<b>Application Ref:</b>	2025/0295			 Ribble Valley Borough Council <a href="http://www.ribblevalley.gov.uk">www.ribblevalley.gov.uk</a>
<b>Date Inspected:</b>	24.06.25	<b>Site Notice:</b>	24.06.25	
<b>Officer:</b>	Stephen Kilmartin			
<b>DELEGATED ITEM FILE REPORT:</b>				<b>REFUSAL</b>

<b>Development Description:</b>	Erection of one new single storey residential building adjacent to The Pentre. Construction of new boundary fence/wall separating the properties.
<b>Site Address/Location:</b>	The Pentre Pendle Road Clitheroe BB7 1JQ

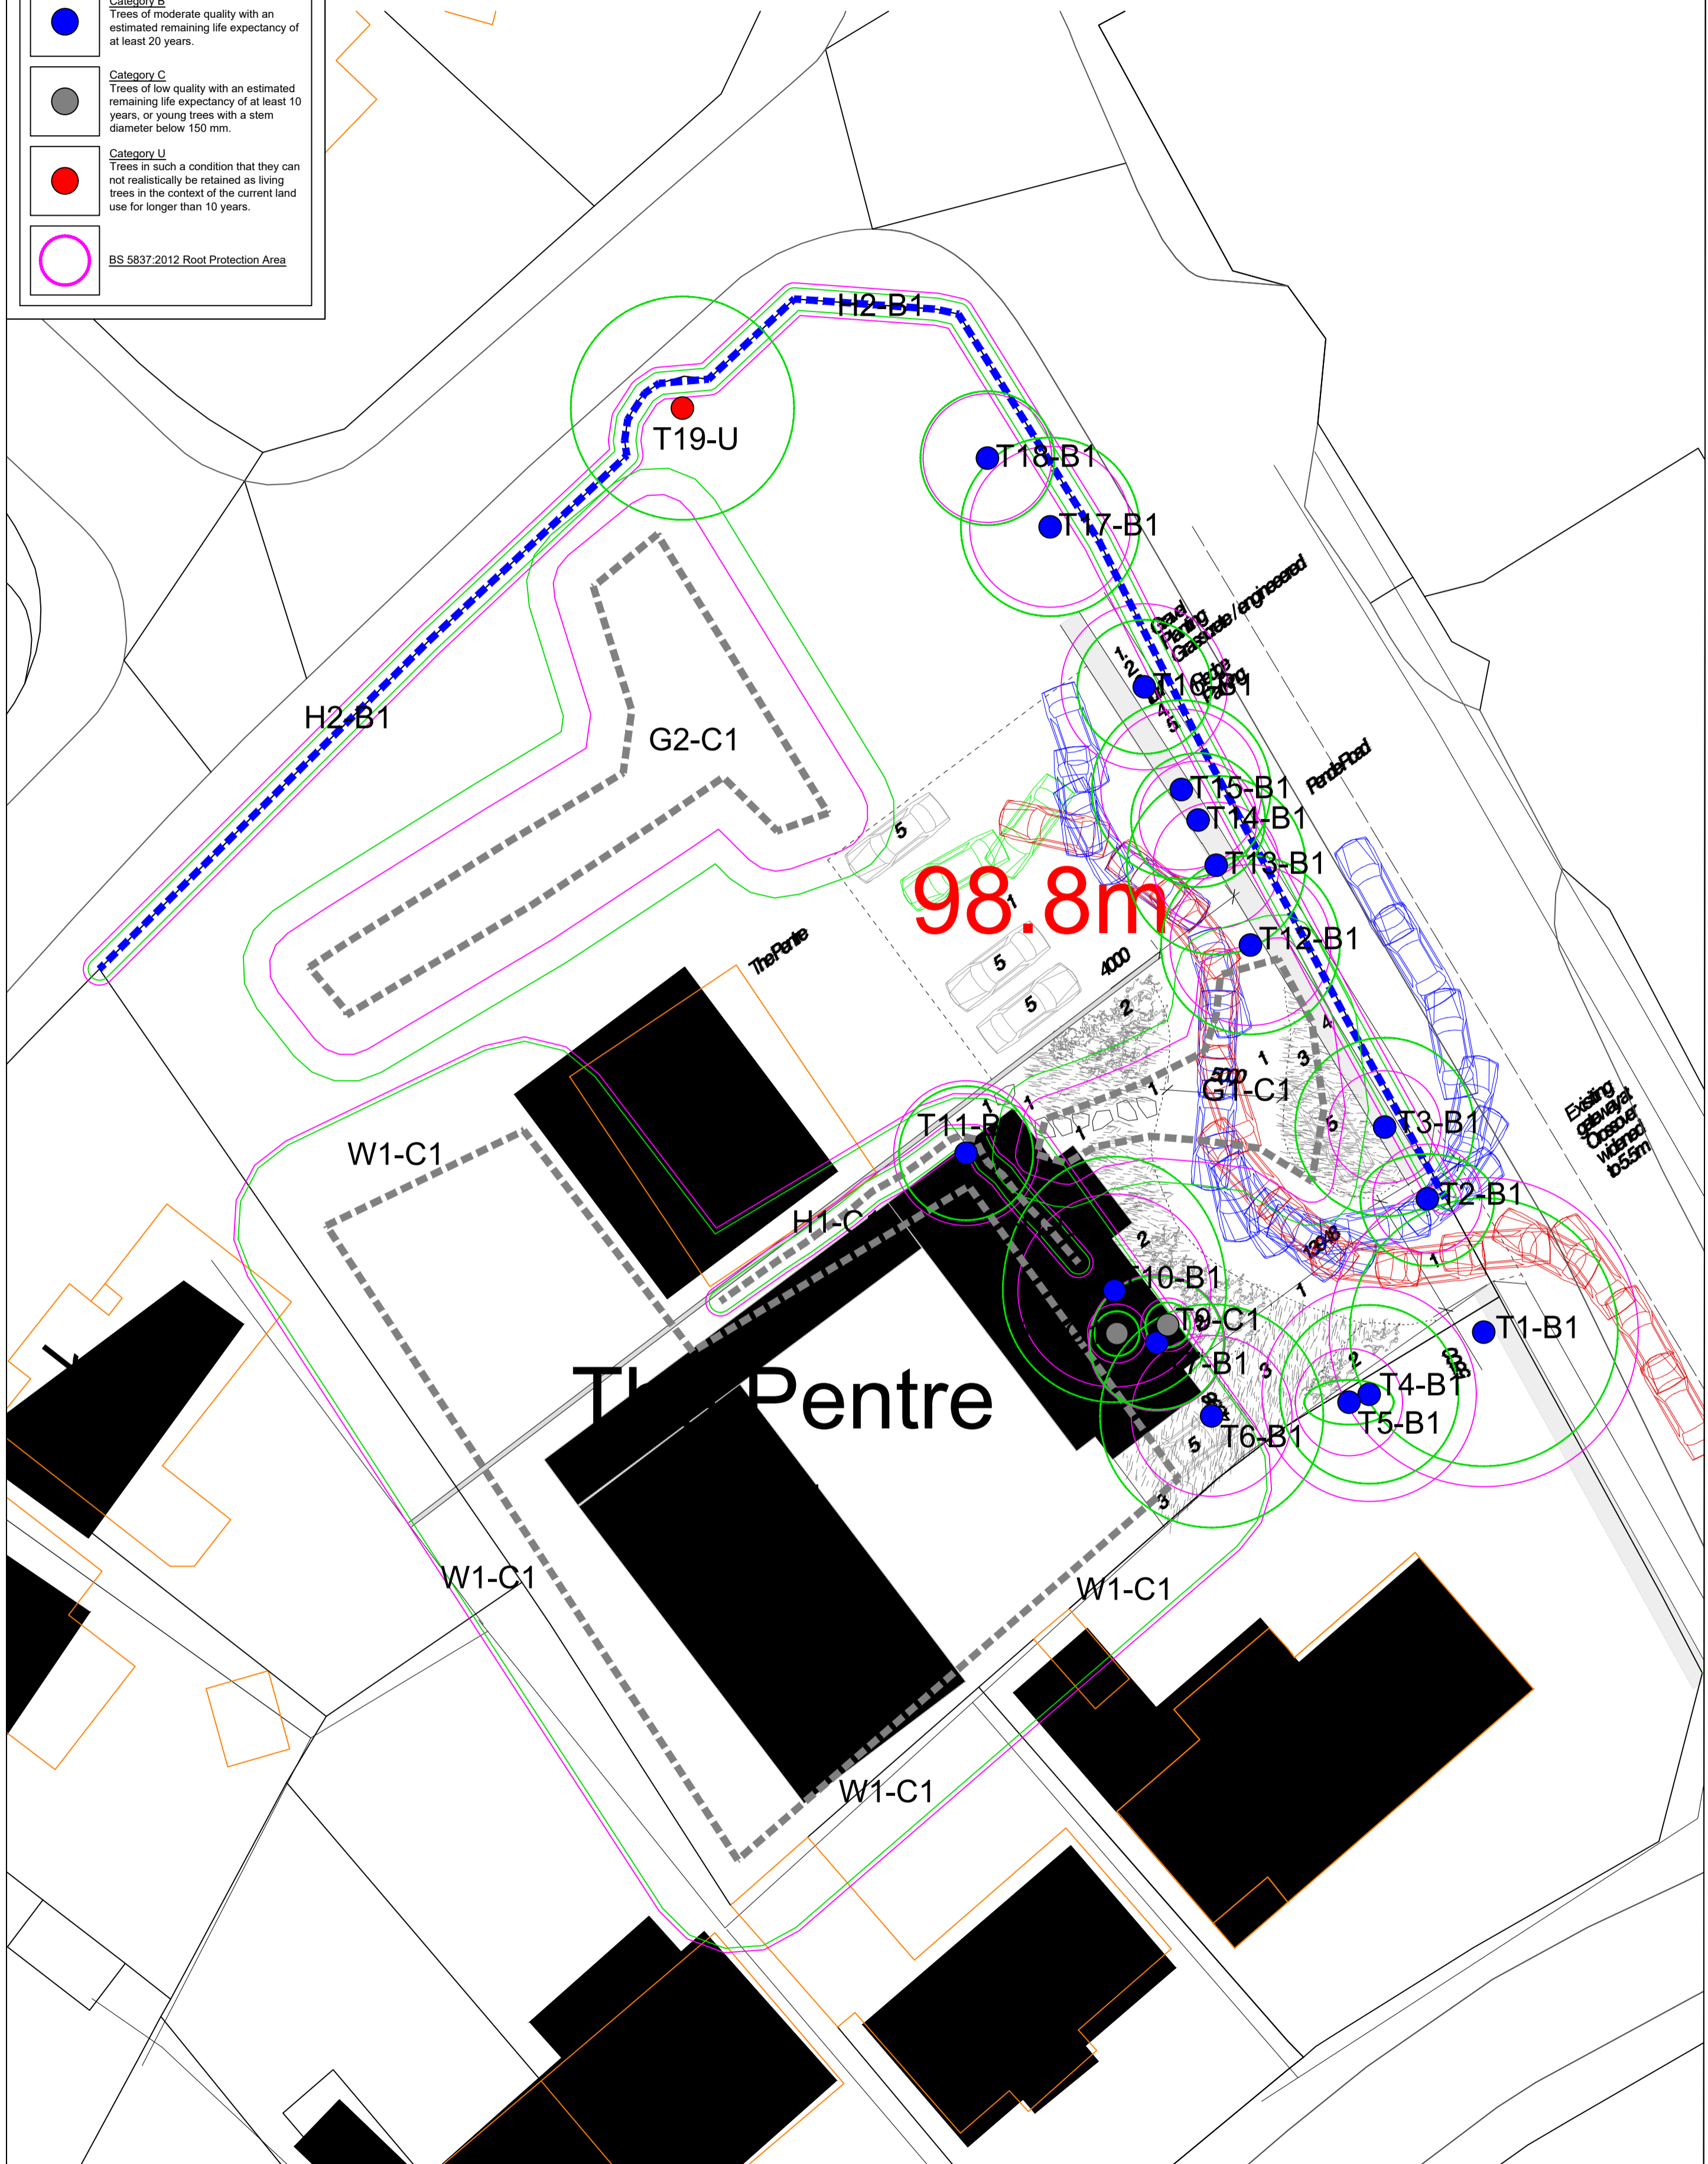
However, in respect of the above matters, no landscaping proposals have been provided that demonstrate adequate mitigation and compensation for the trees, scrub and hedgerow to be lost. Furthermore, taking account of the footprint of the proposed dwelling and the remaining undeveloped site area, the authority does not consider that such mitigation and enhancement could reasonably be achieved on site.

As such and taking account of the above, the proposals results in significant direct conflict with Key Statement EN4 and Policies DME1, DME2 and DME3 of the Ribble Valley Coire Strategy. Particularly insofar that it has not been adequately demonstrated that the proposal will result in an overall net enhancement in biodiversity, nor has it been demonstrated that the proposed loss of trees, hedgerow and habitat can be adequately compensated for on- site.
